**Harnett County**  
420 McKinney Pkwy  
LILLINGTON, NC 27546  
Phone:  
Fax:

**SUBJECT: SFD2107-0065  
SINGLE FAMILY DWELLING**

Here are the results of all Inspections located at **200 GILCHRIST RD:**

CONCRETE BLOCK PIER DETAIL  
NOT TO SCALE

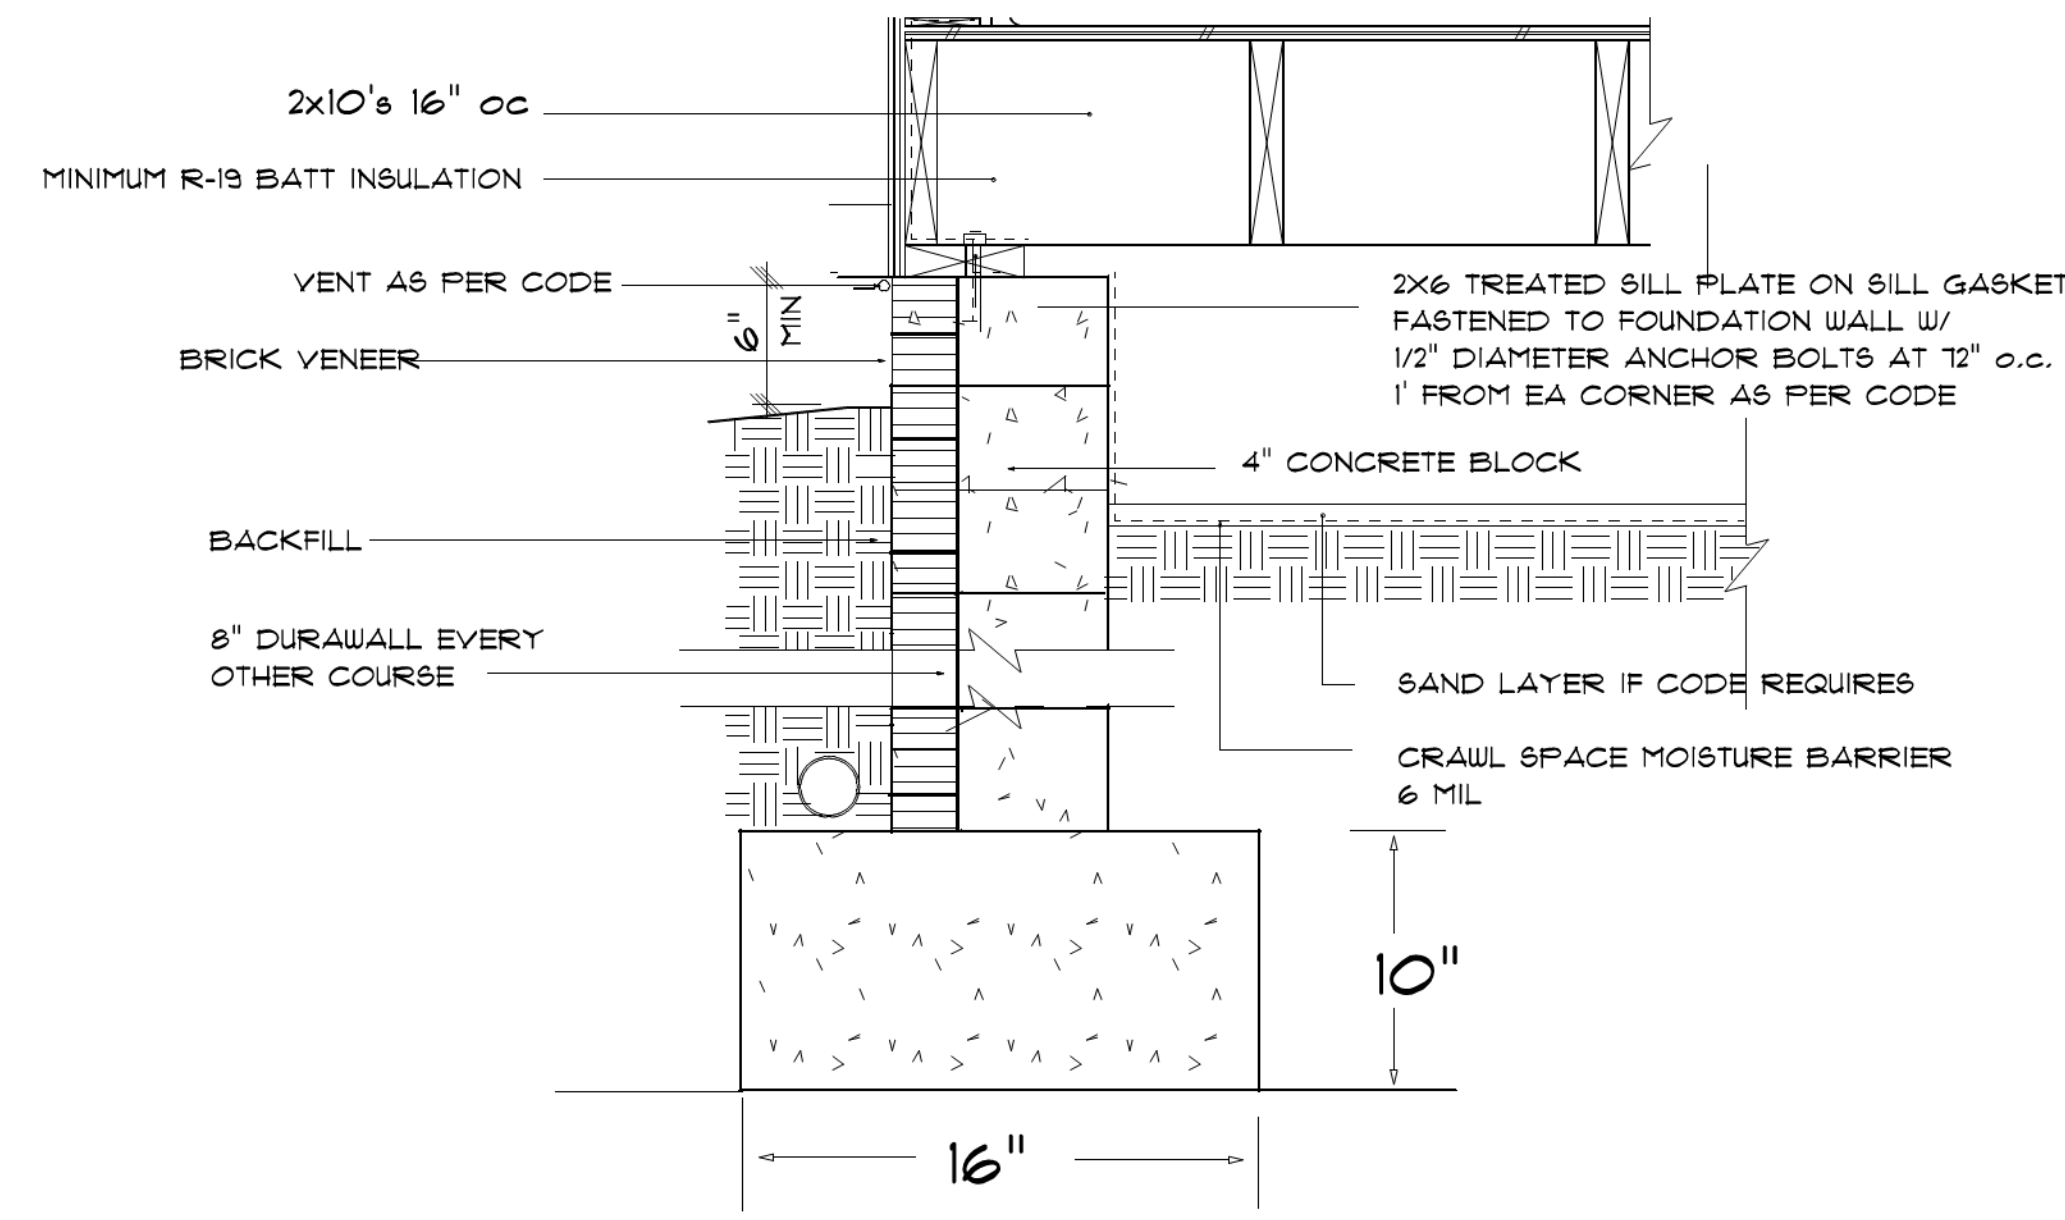
Missing roofing/flashings. Missing doors and windows. Porches not flashed. Missing roof boots missing tie backs on rafters. Shower pan liner not installed. Kitchen outlets not roughed in. Missing mid story strap and nail plate on hvac line set. Garage door opening must comply with portal frame detail. Plumbing drain test down. Showers not framed. Missing insulation and air barrier behind tub. Missing insulation baffles. Missing hangers or ledger strips on exiling joists. Missing lvl sheets. Provide engineering letter on sticker framed roof lvl's to ridge connections. Outlets missing wiring in office. Not all wiring pulled into panel. Wiring not secured. Draft stop top off office wall. Seal all plate penetrations. Girders must fully bear on piers. Missing double joists. Rear deck not finished with framing.

FOUNDATION PLAN  
SCALE: 1/4"

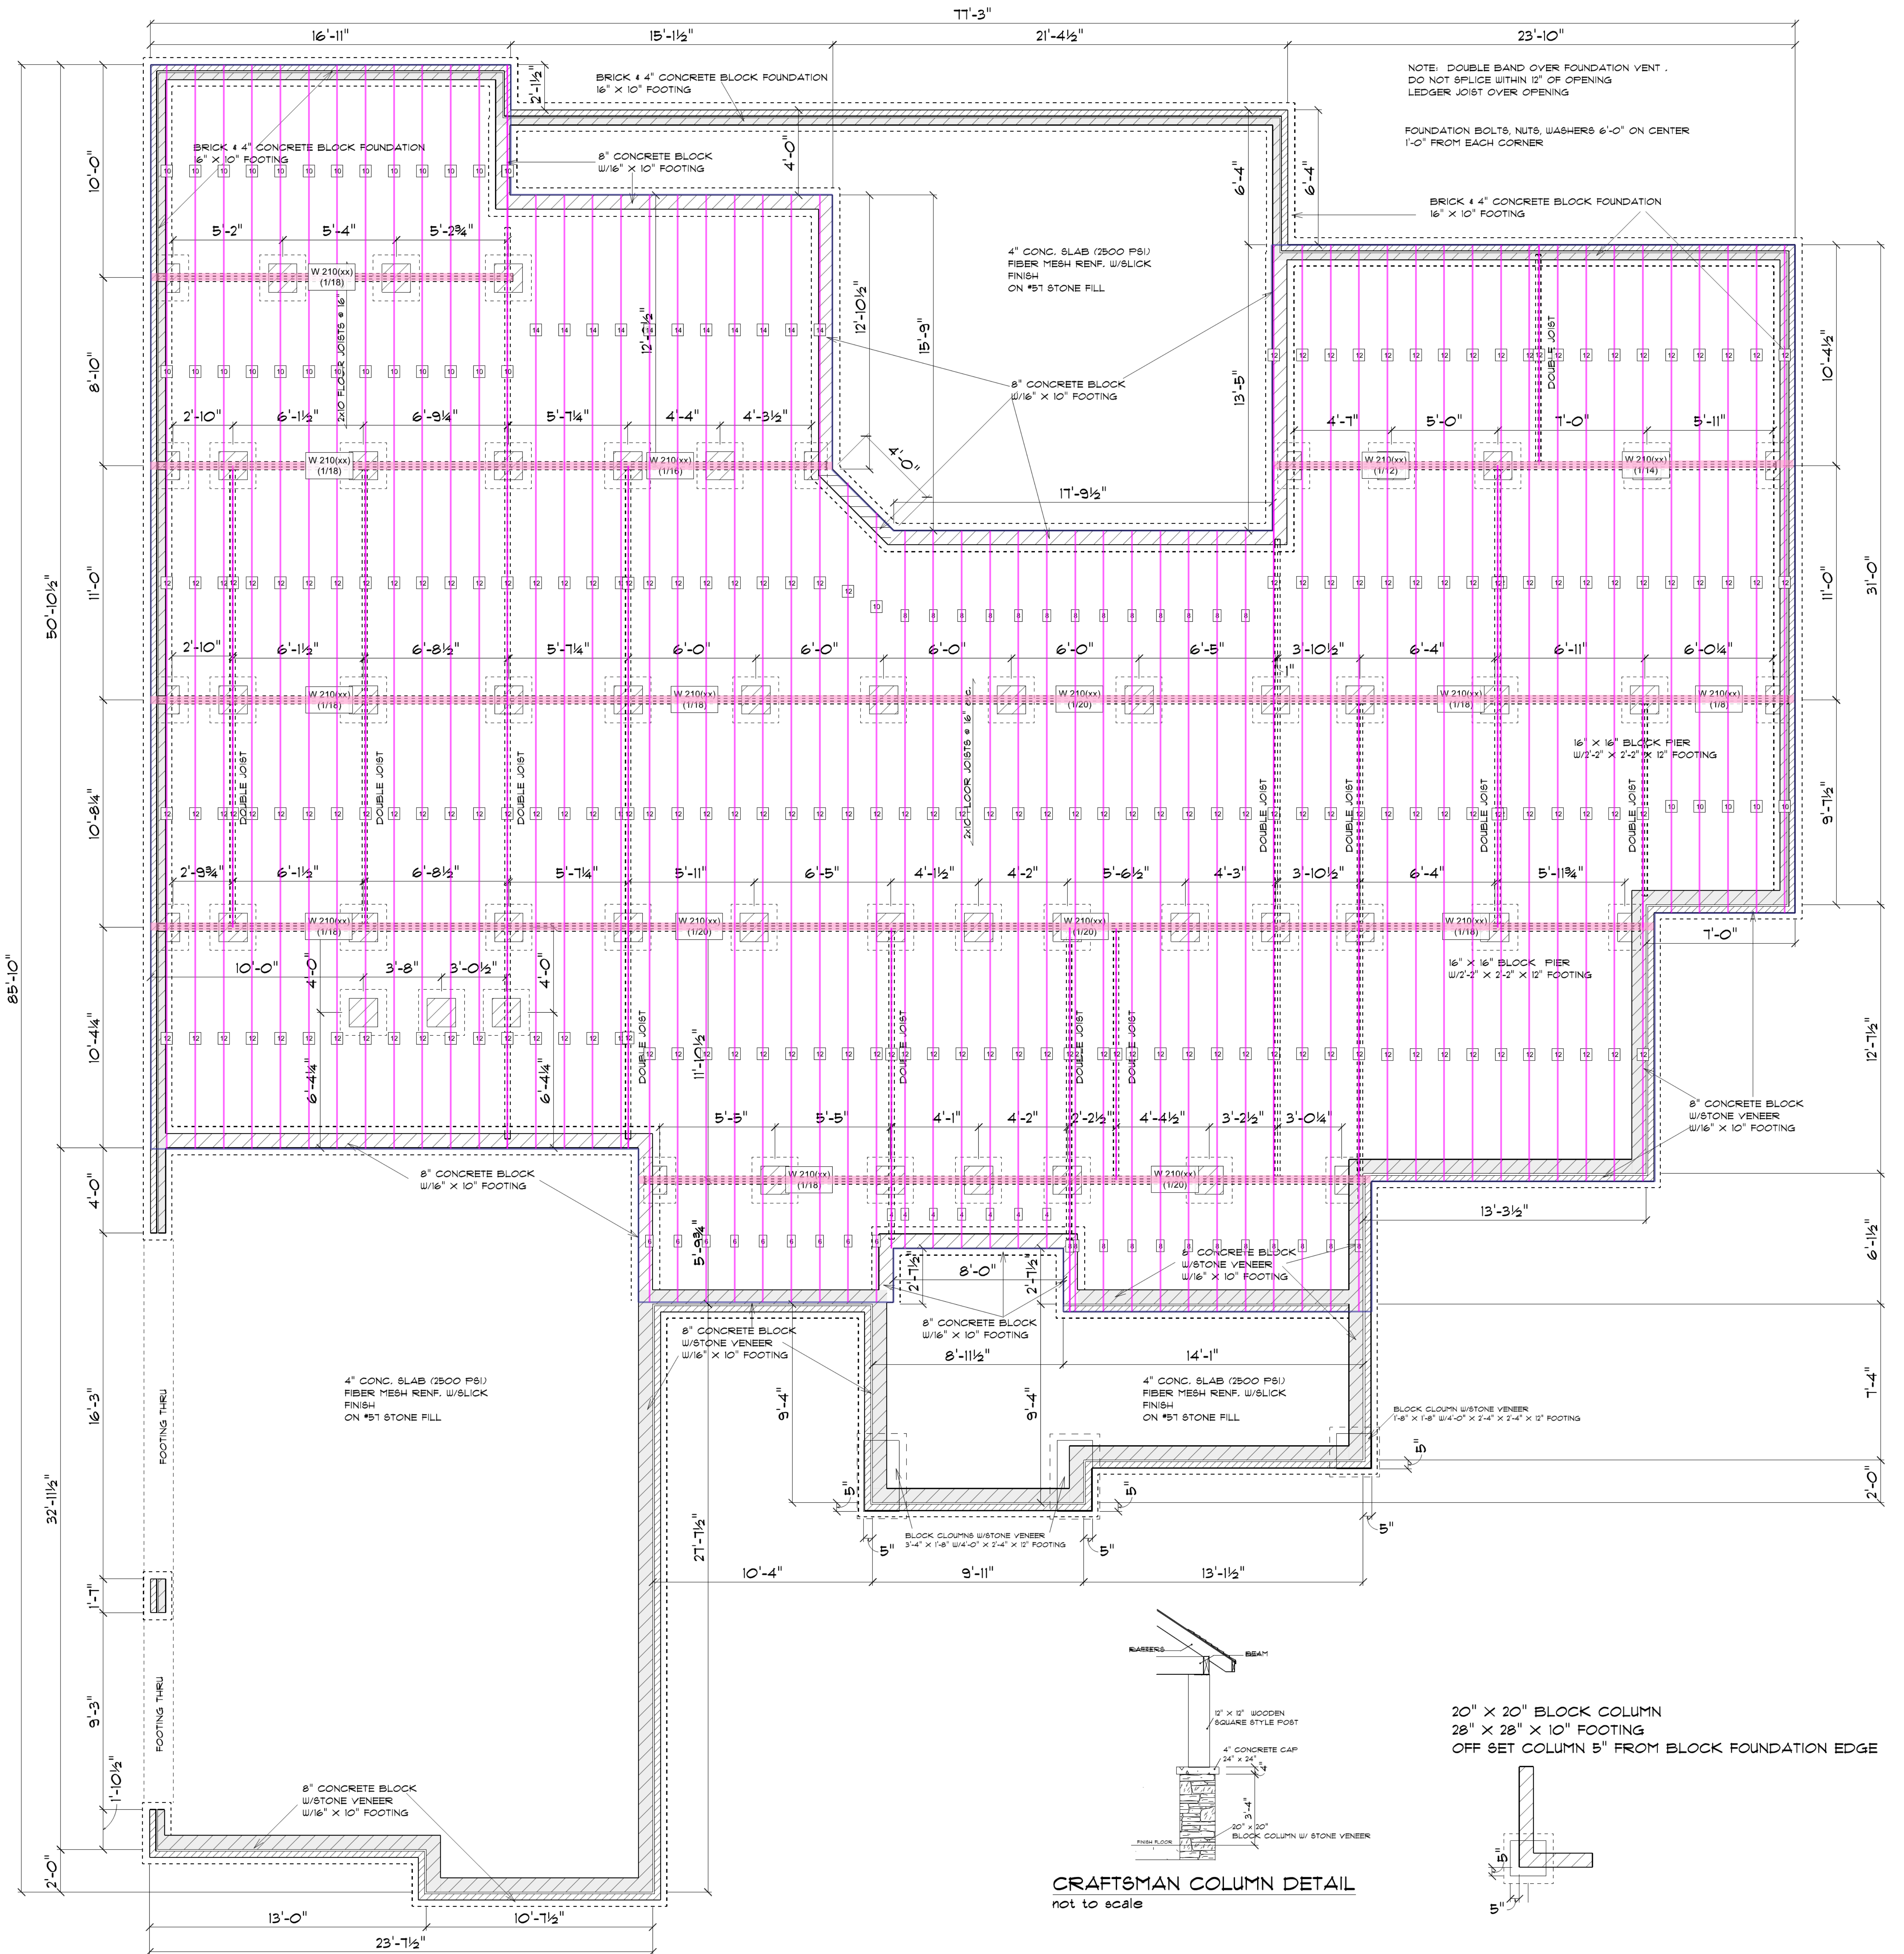
Must have plan reviewed plans onsite with plan review stamp. Several piers do not meet minimum projection, provide engineering. Clean top of footers to allow for inspection of bed joints. Missing foundation damp proofing.

Inspection Type: FOUNDATION  
Scheduled Date/Time: 11/18/2021  
Completed Date/Time: 11/18/2021  
Inspector: Steven Gazlay  
Result: APPROVED W/EXC  
Remarks: eTRAKiT Inspection Request  
Notes: eng letter in file  
Missing foundation damp proofing.
